## **Christmas Holiday Temp Use - Letter of intent (9525 Burgess Rd)**

**APPLICATION: TU1936; ACCESS PERMIT: AP20994**

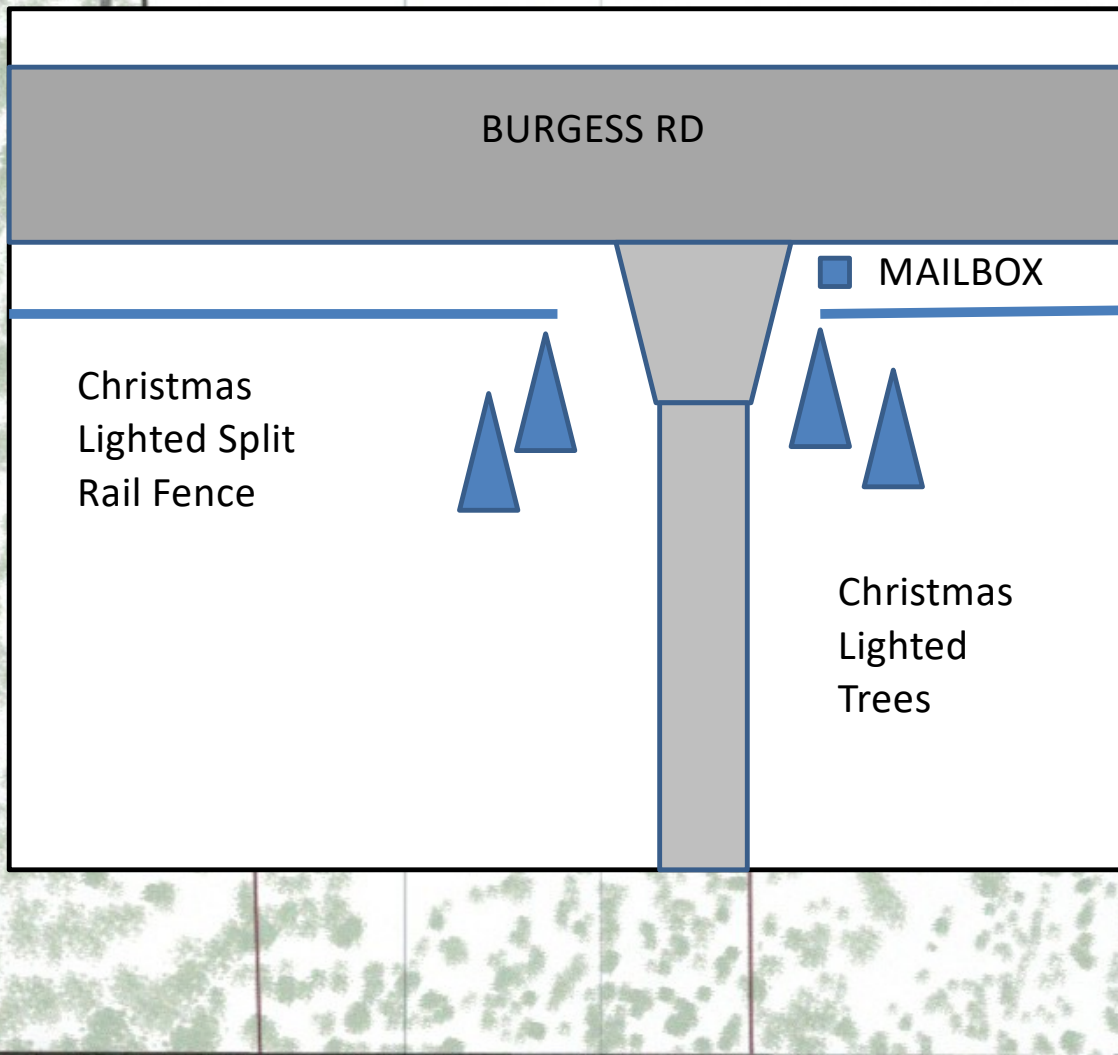
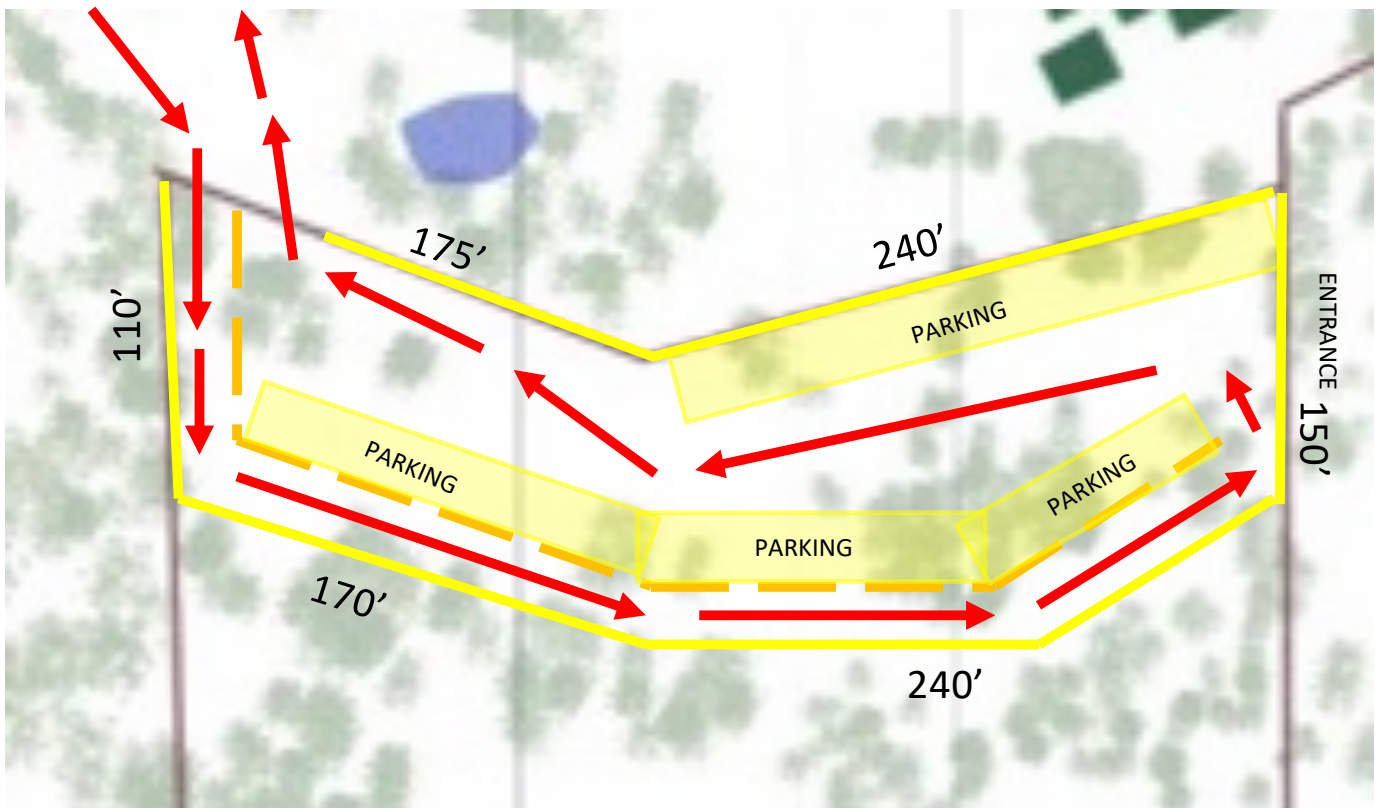
25' setbacks are required for structures. Generally we recommend temp uses be setback as well. Your plan shows compliance with the 25' setbacks if that is what the black dashed lines represent.
